88 Albert Street & 81 Slater Street | Formal Review | Site Plan Control application to permit construction of a 25 floor residential building | rla / architecture; 88 Albert Street Holdings Inc.; Fotenn Planning + Design.

Figure 1.18 Ground Floor Plan

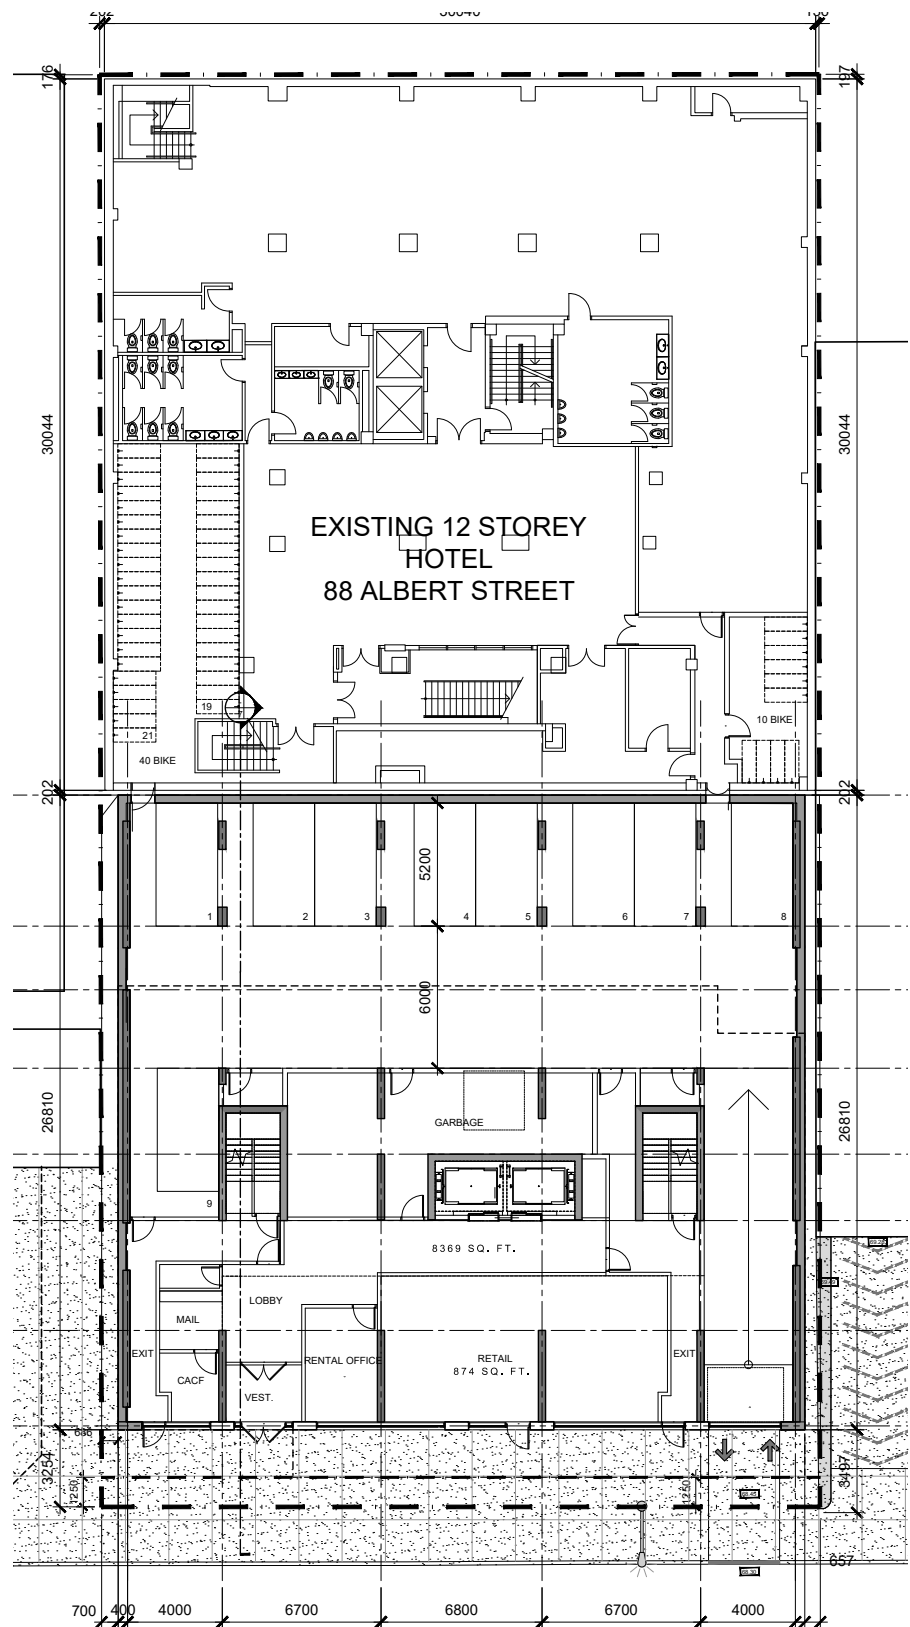
- The Panel suggests that there could be more space between the retail entrances and the exterior access to the garbage room.

Figure 1.21 Typical Plans for Floors 3-12

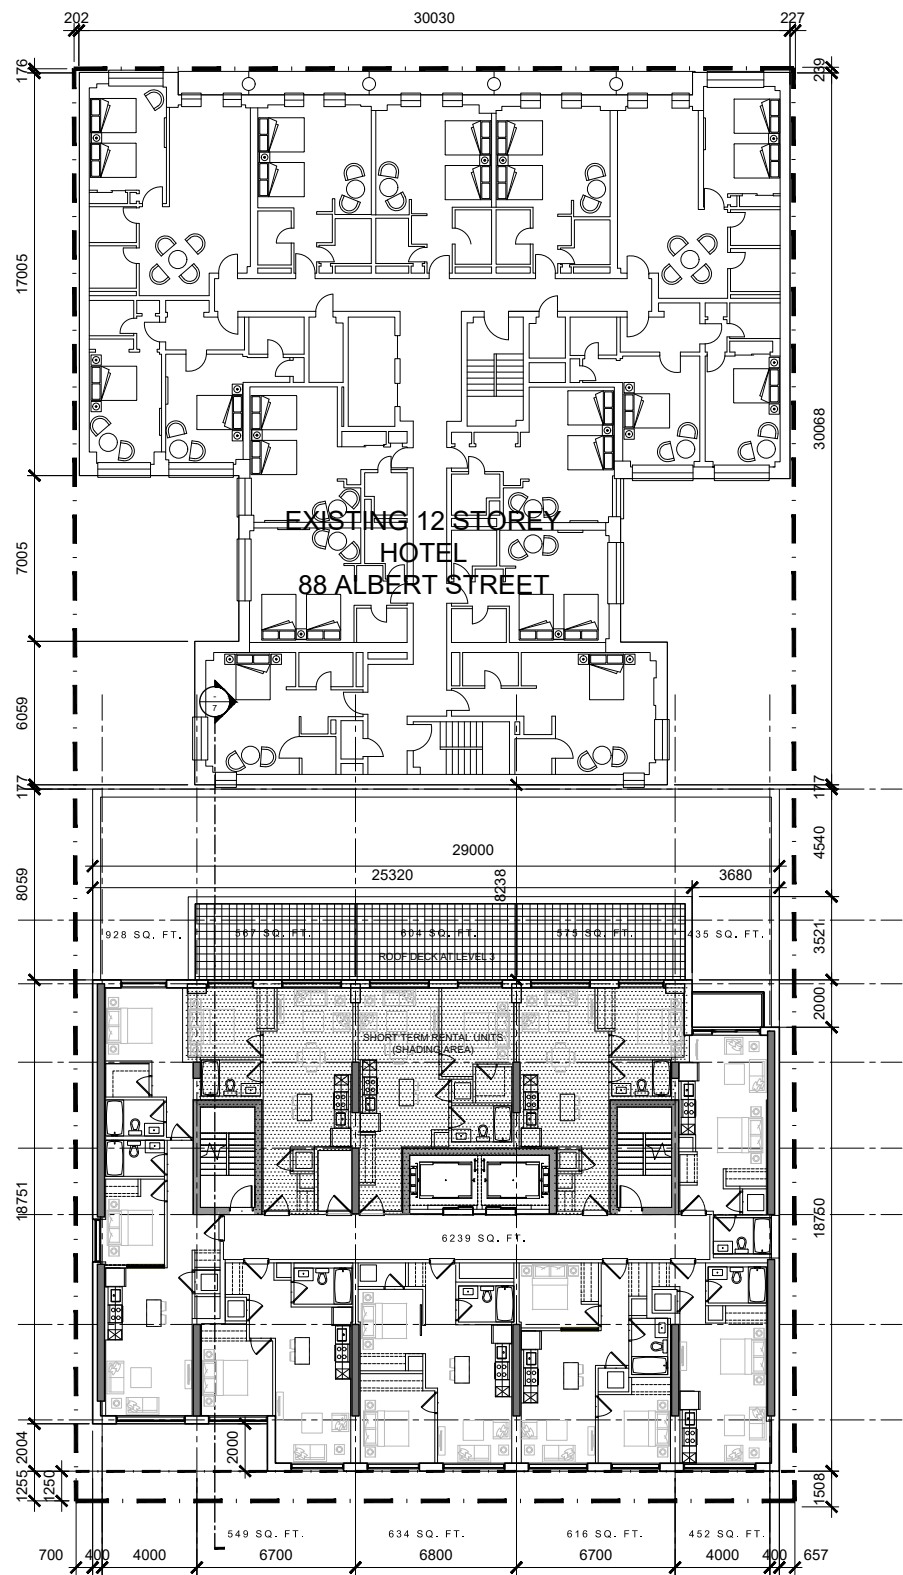
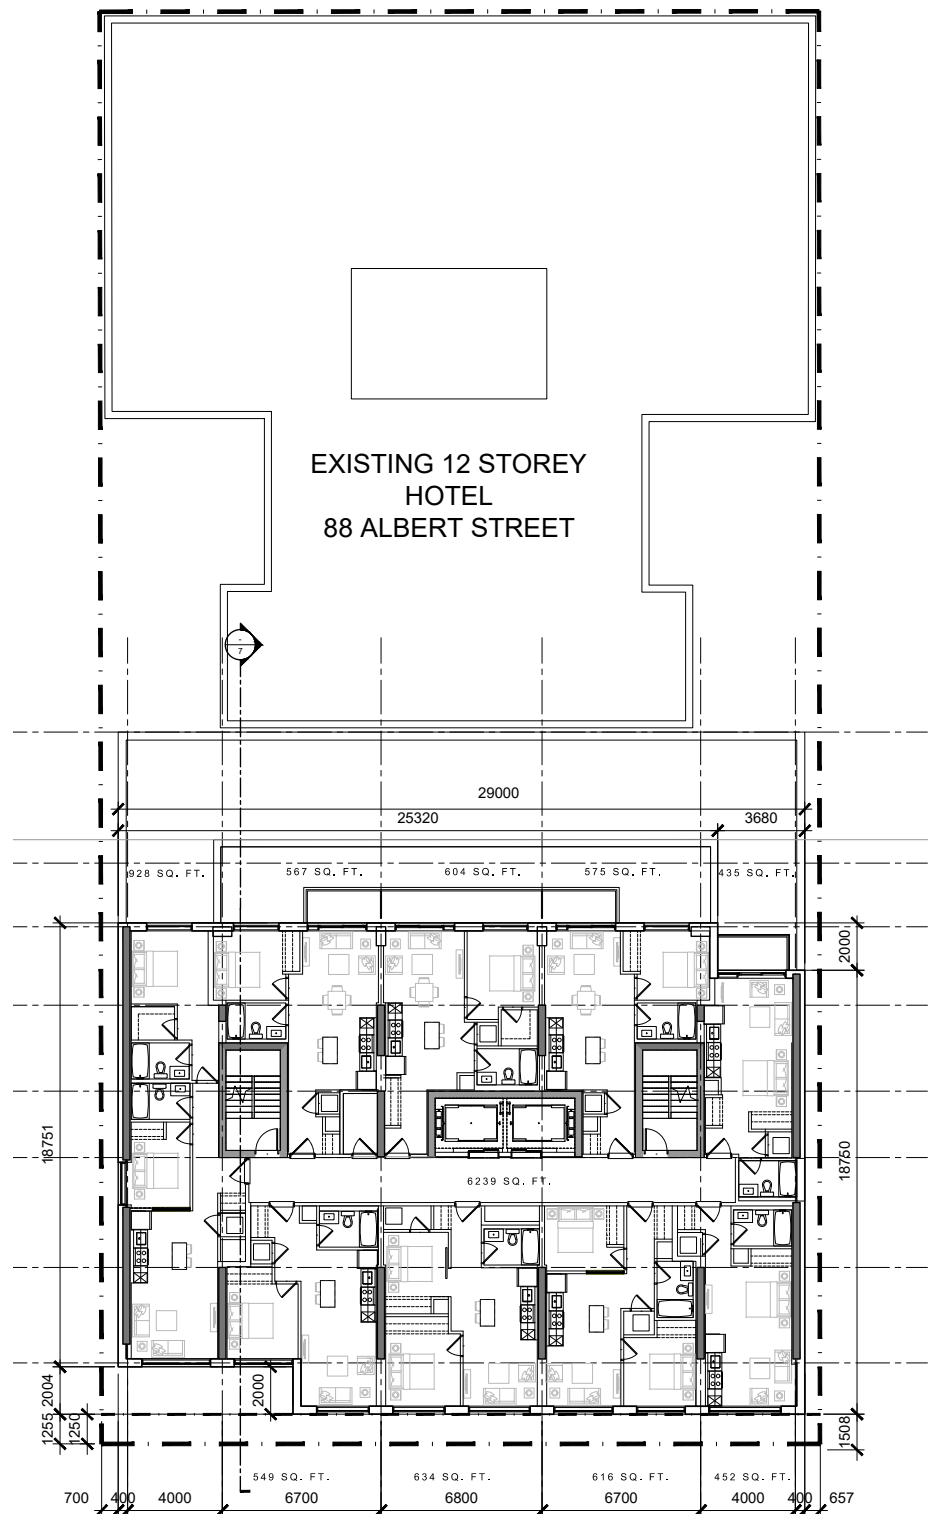
- Lower the lighter coloured portion of the building down to the 12th floor. Retain the dark coloured portion of the tower above the 12th floor but maintain the 3.6-4m setback on the east side above the 12th floor. The same setback should then apply to the west side.

- The Panel is concerned with the quality of life issues created by the 7.5m setback at the rear, as this space will not allow light between the proposed building and the existing hotel.

- A smaller footprint is recommended in order to achieve a larger rear setback.
 - In a scenario where the existing hotel is demolished and the site redeveloped with a 7.5m rear setback, it would still result in a very constrained relationship with only 15 meters between the two buildings between the two buildings.

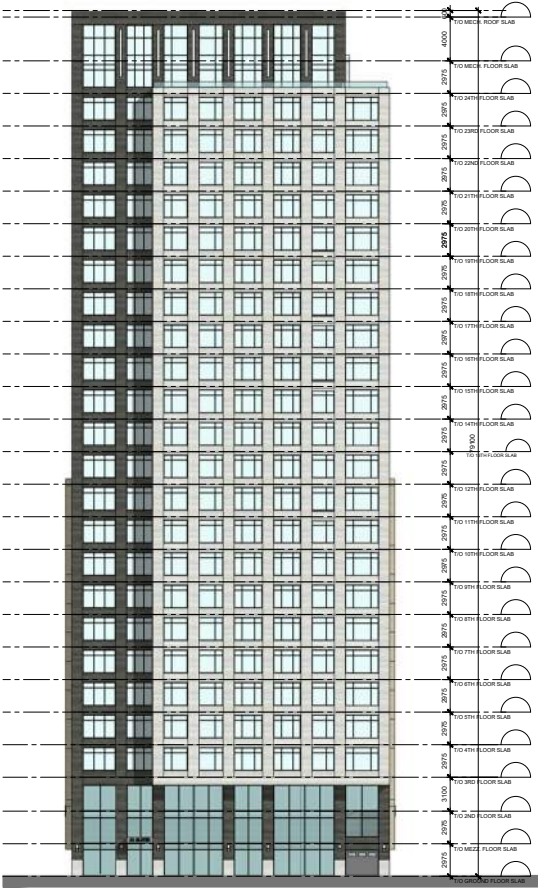
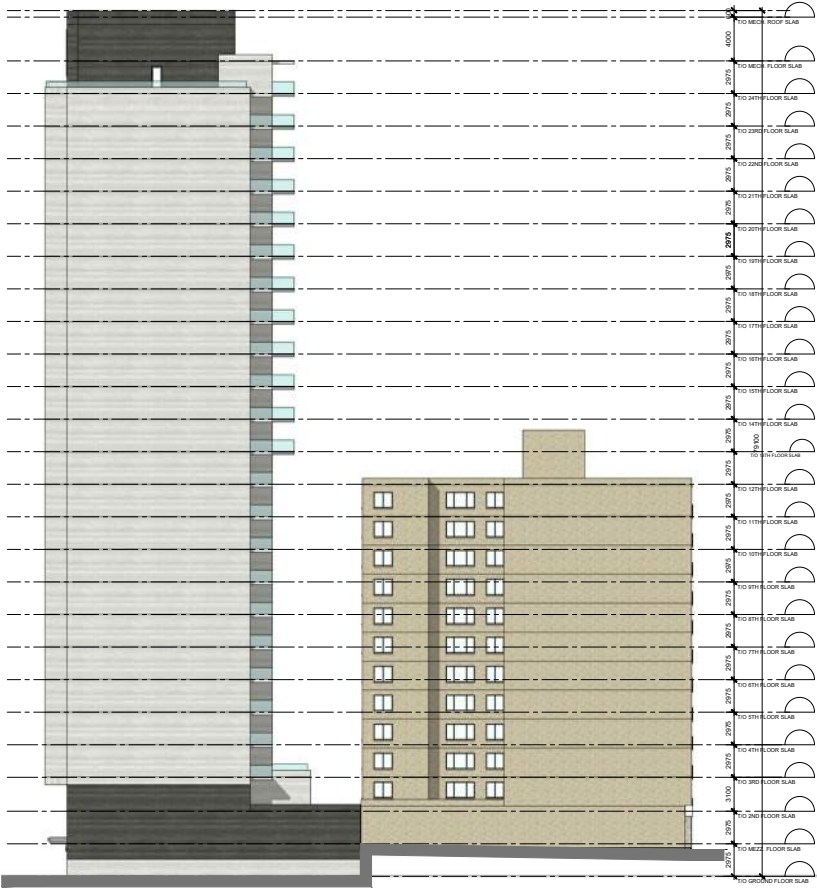
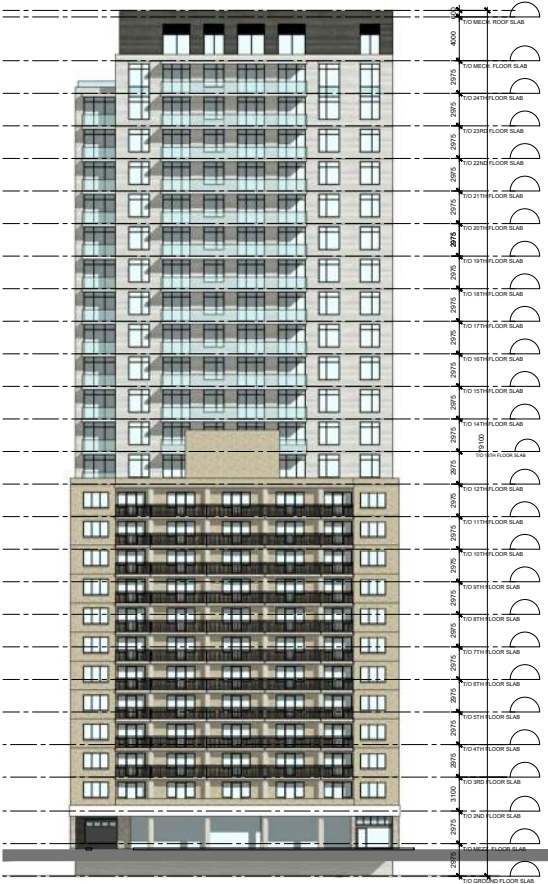
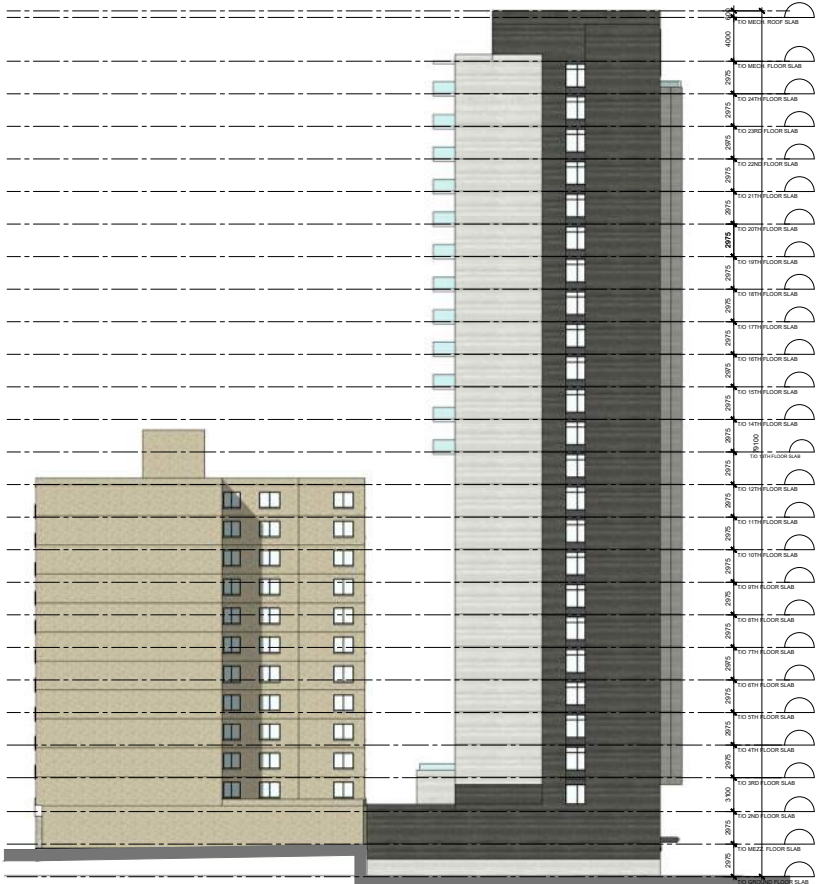
- The Panel suggests better detailing of the base to avoid a utilitarian character, providing a more elegant impact on the public realm. The adjacent federal building facing Elgin Street provides a good example.
- The Panel suggests eliminating the blank facades on the sides of the buildings by applying the suggestion above with respect to carving out side yard setbacks above the 12th floor. This breathing room will greatly improve the buildings relationship with the neighbouring towers.
- One suggestion from a Panel member is to apply the same approach used in the expression of the vertical plane above, to the base of the building.
- A Panel member has concerns that the current proposal may lead to difficulties ensuring that the mechanical roof stays under the maximum height restriction.
